**Subject:** Rezoning Petition Review

**Rezoning Petition #:** 21-177

**Location of Property:** Approximately 2.13 acres located in the southeast quadrant of the intersection of Mallard Creek Rd and West WT Harris Blvd, west of IBM Dr.

SHEET NUMBER:
 RZ-1

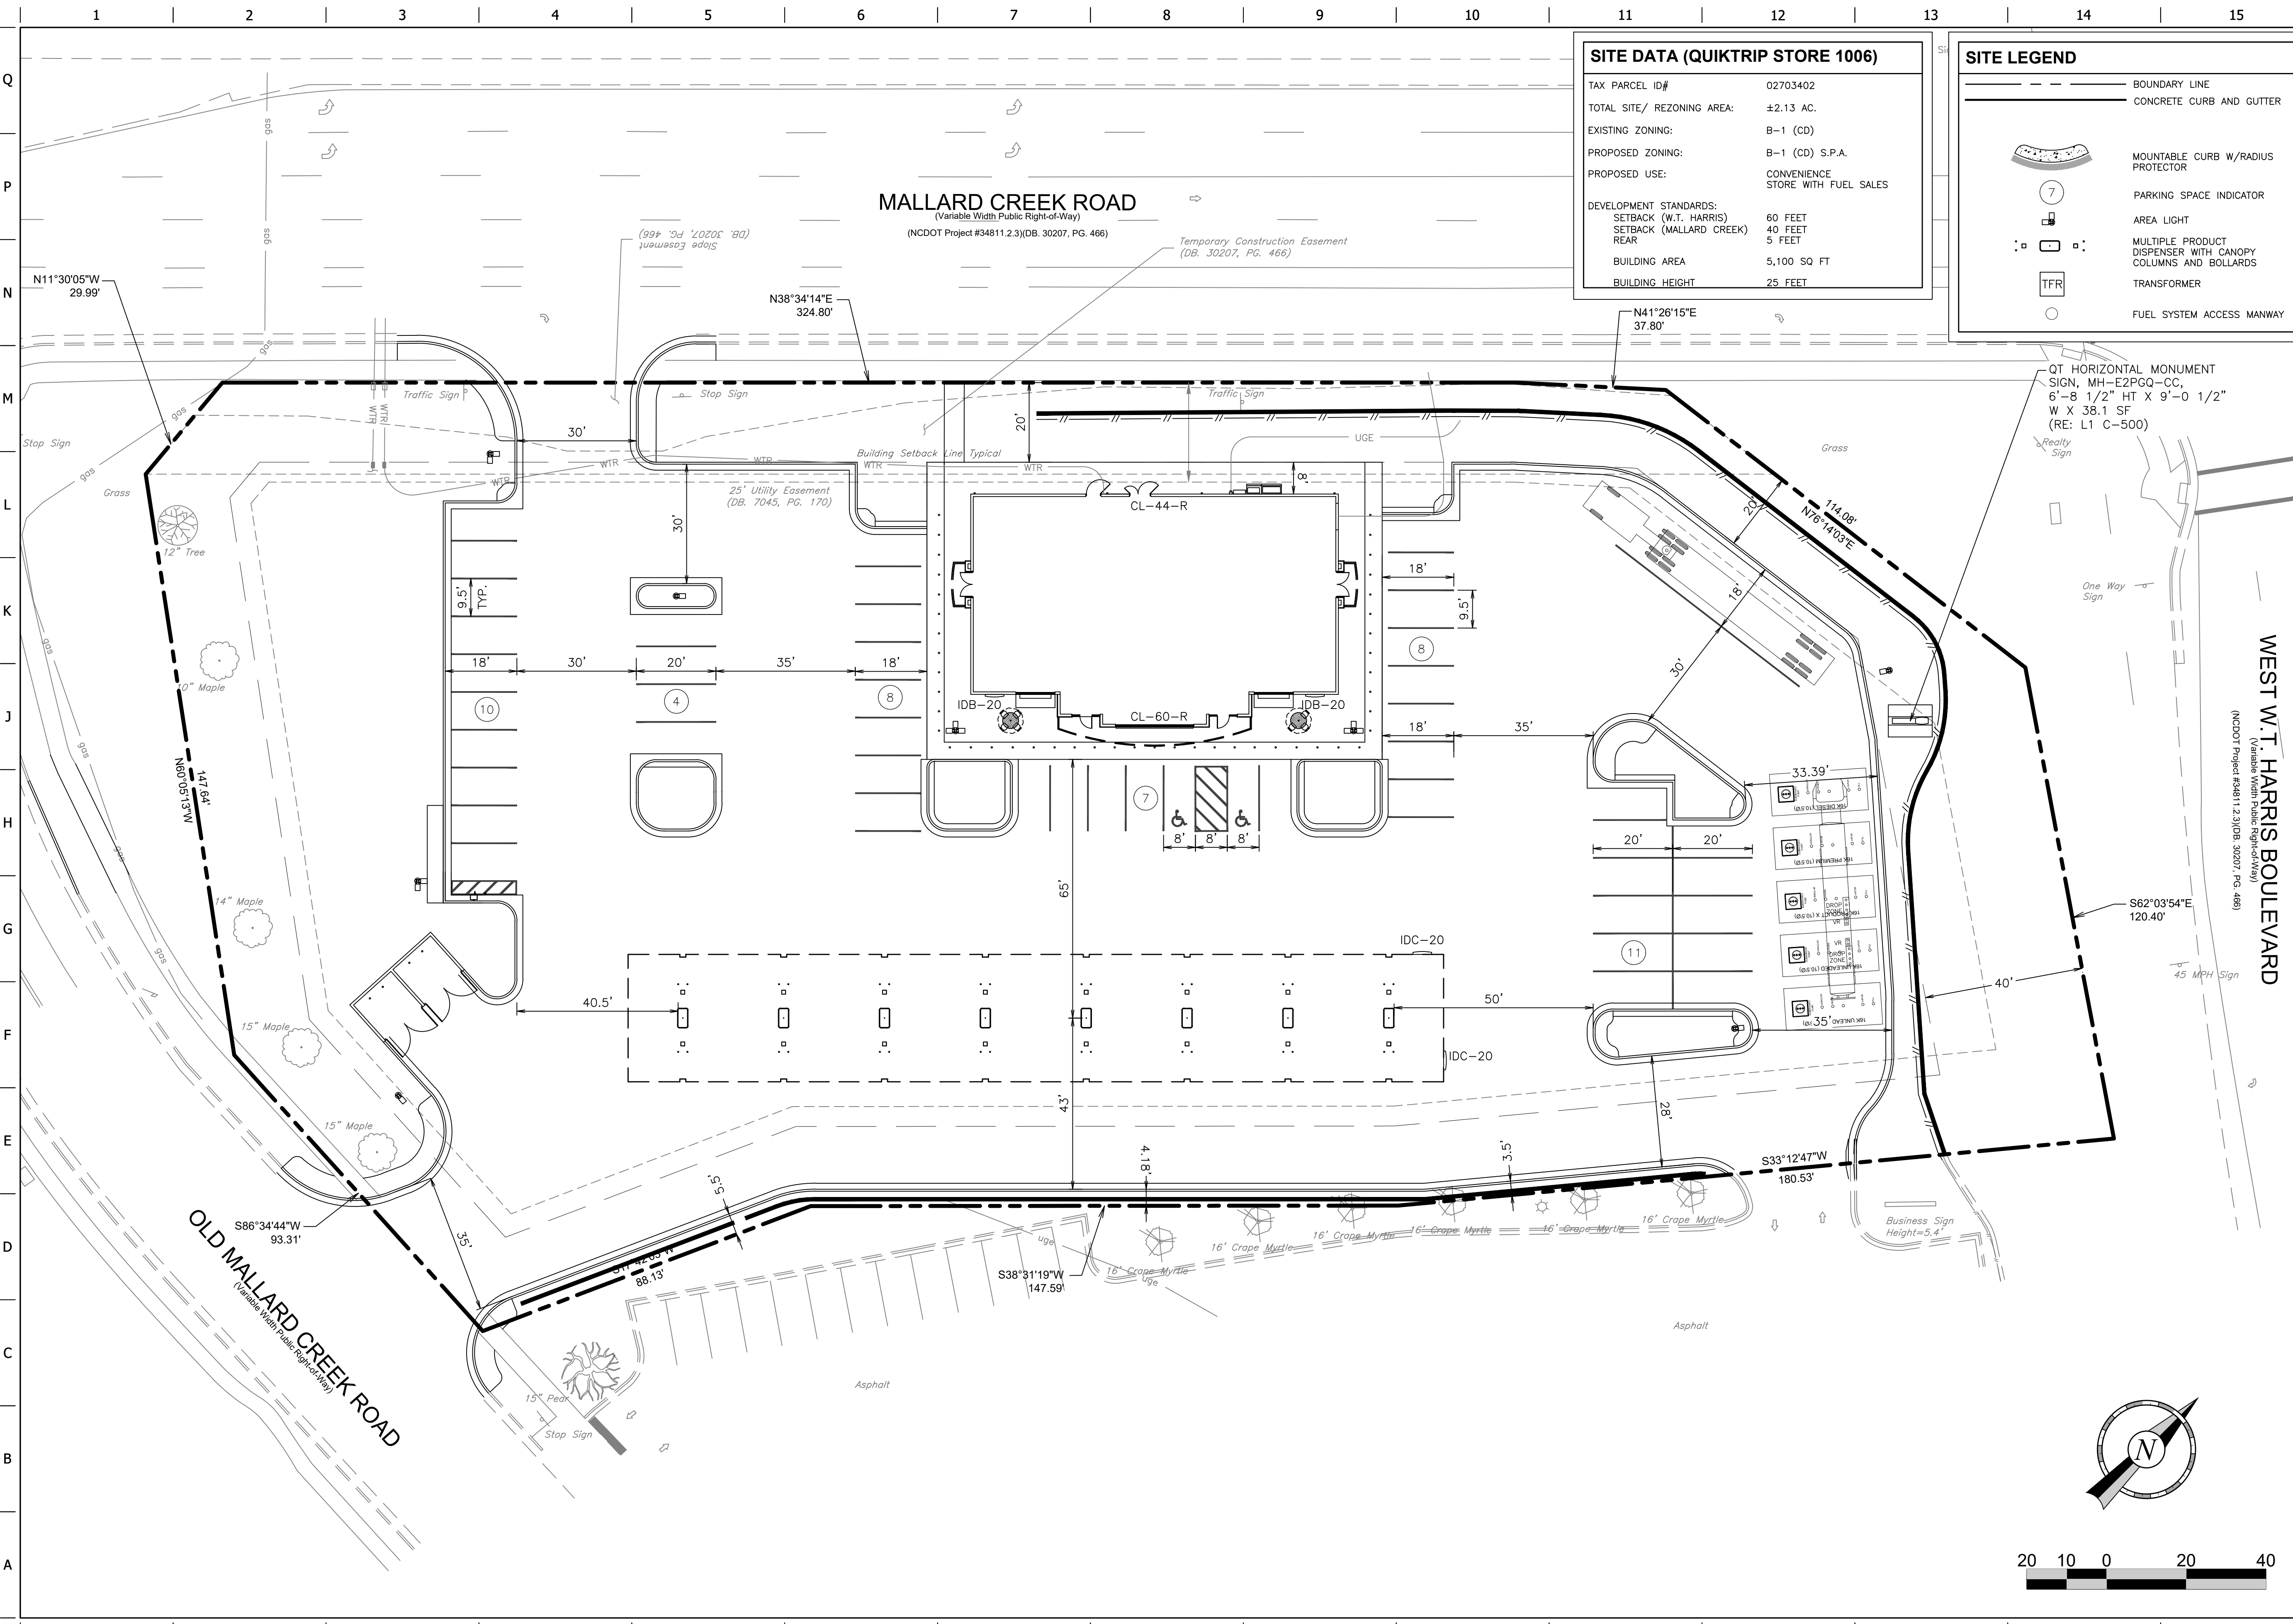
**This property drains to Mallard Creek, which is an impaired/degraded stream, and may contribute to downstream flooding. This project has the opportunity to mitigate future impacts to this stream, therefore, Storm Water recommends placing the following notes on the plan:**

For defined watersheds greater than 10% built-upon area (BUA), construct water quality stormwater control measures (SCMs) designed for the runoff generated from the first 1-inch of rainfall for all new and redeveloped BUA associated with the project. SCMs must be designed and constructed in accordance with the Charlotte-Mecklenburg BMP Design Manual.

For defined watersheds greater than 10% built-upon area, control the entire volume for the 1-year, 24-hour storm for all new and redeveloped BUA associated with the project. Runoff volume drawdown time shall be in accordance with the Charlotte-Mecklenburg BMP Design Manual.

For commercial projects with greater than 10% BUA, control the peak to not exceed the predevelopment runoff rates for the 10-yr, 6-hr storm and perform a downstream flood analysis to determine whether additional peak control is needed and if so, for what level of storm frequency, or if a downstream analysis is not performed, control the peak for the 10-yr and 25-yr, 6-hour storms.
